**EL PASO COUNTY**

**Subject: Forest Lakes Filing No. 6 Final Plat, Preliminary Comments (SF-20-027)**

### Forest Lakes Filing No. 6 Final Plat Development Application Review

14770

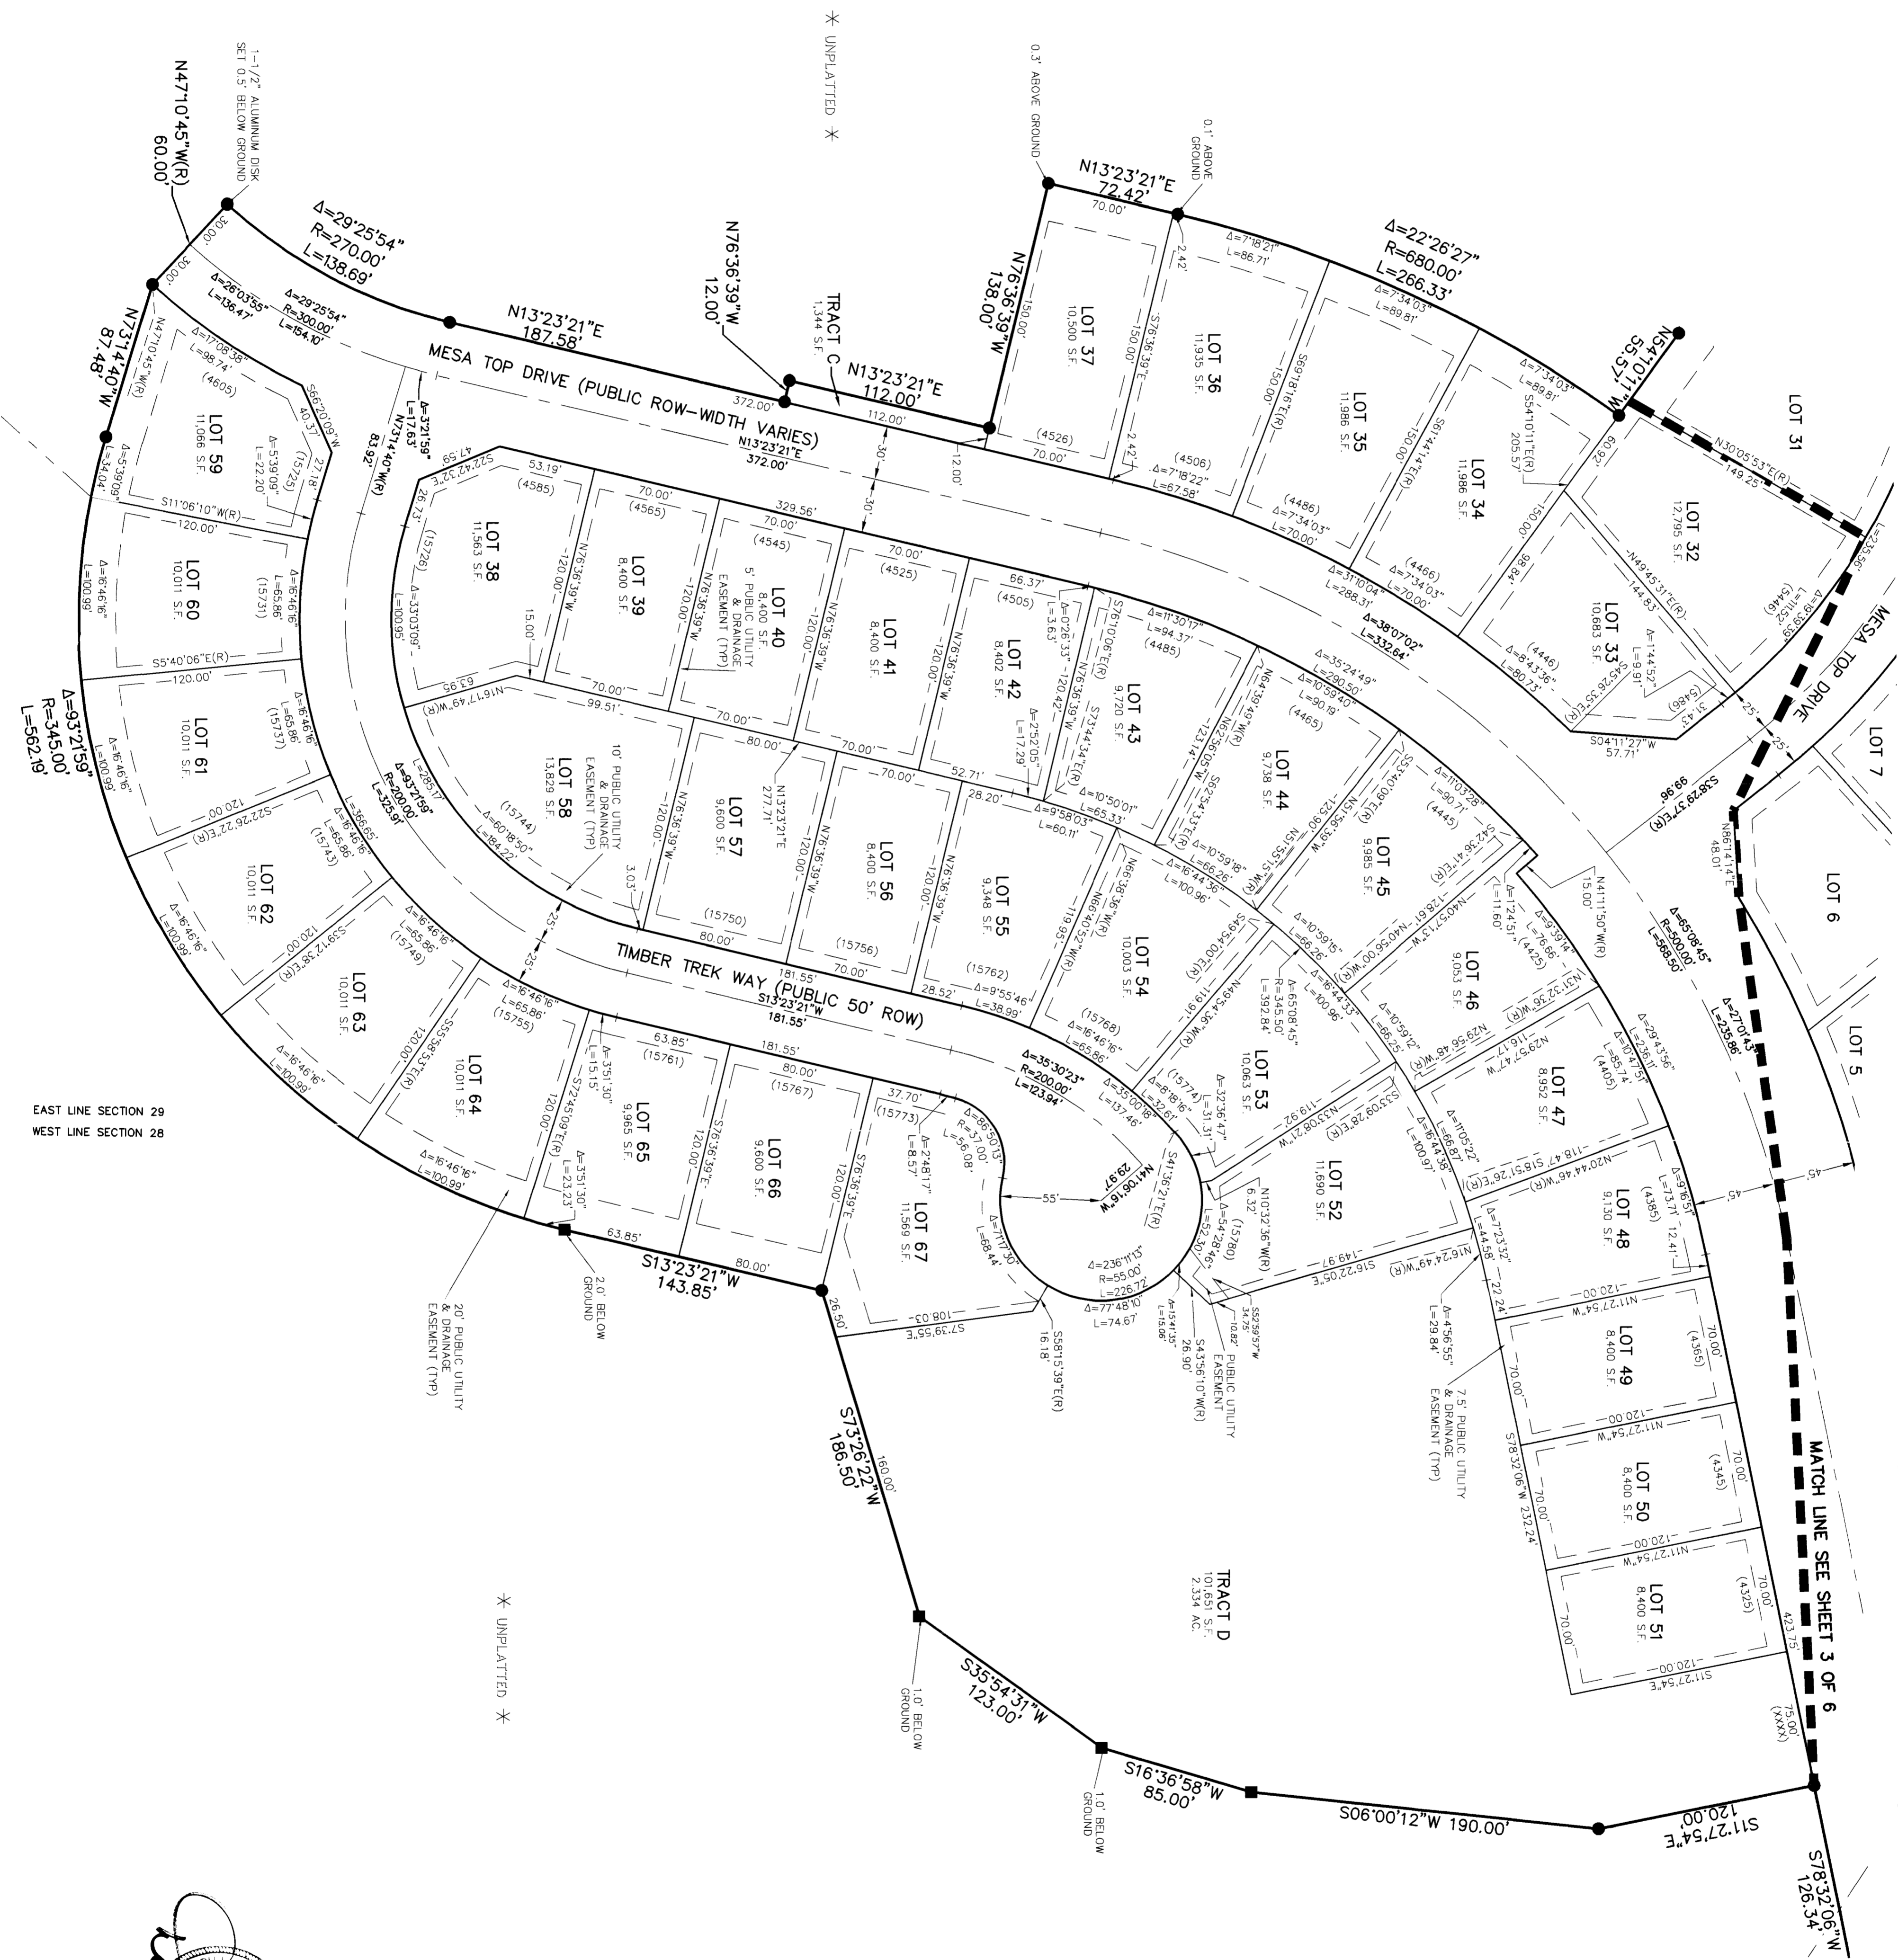
The BoCC-approved Forest Lakes Phase II PUD Preliminary Plan shows in detail the Forest Lakes Secondary Regional Trail, as well as the internal trail network and emergency access road. However, the Forest Lakes Filing No. 6 Final Plat does not show the 25-foot trail easement through the project site, and the Final Plat notes do not reference the dedication of the trail easement to El Paso County. As such, staff recommends that the applicant include the easement alignment in the Final Plat drawings and include language in the Final Plat General Notes that designates and provides to El Paso County a 25-foot trail easement through Forest Lakes Filing No. 6, within Tracts A and B, that allows for public access of the Forest Lakes Secondary Regional Trail, and dedicate the aforementioned easement to El Paso County prior to the recording of the Final Plat.

*The Park Advisory Board recommends that the Planning Commission and the Board of County Commissioners include the following conditions when considering and/or approving the Forest Lakes Filing No. 6 Final Plat: (1) designate and provide to El Paso County a 25-foot trail easement through Forest Lakes Filing No. 6 Final Plat, within Tracts A and B, that allows for public access of the Forest Lakes Secondary Regional Trail, and dedicate the easement to El Paso County within the Final Plat General Notes prior to the recording of the Final Plat; (2) regional park fees are not required pursuant to the existing Forest Lakes Phase I PUD Preliminary Plan and Filing No. 1 Final Plat recommended and endorsed motions; (3) the section of the Forest Lakes Secondary Regional Trail located within Filing No. 6 shall be constructed within two years of the recording of the Final Plat; (4) trail plans shall be submitted to and approved by County Parks prior to construction; (5) the trail shall be constructed to Tier 1 standards for a regional trail; (6) the trail shall be maintained by the Forest Lakes Metropolitan District when contained within developer-owned tracts, while El Paso County agrees to maintain the Regional Trail when contained within dedicated roadway rights-of-way; (7) require fees in lieu of land dedication for urban park purposes in the amount of \$20,060. A Park Lands Agreement may be an acceptable alternative to urban park fees, provided the agreement is approved by the County and executed prior to recording the Final Plat.*
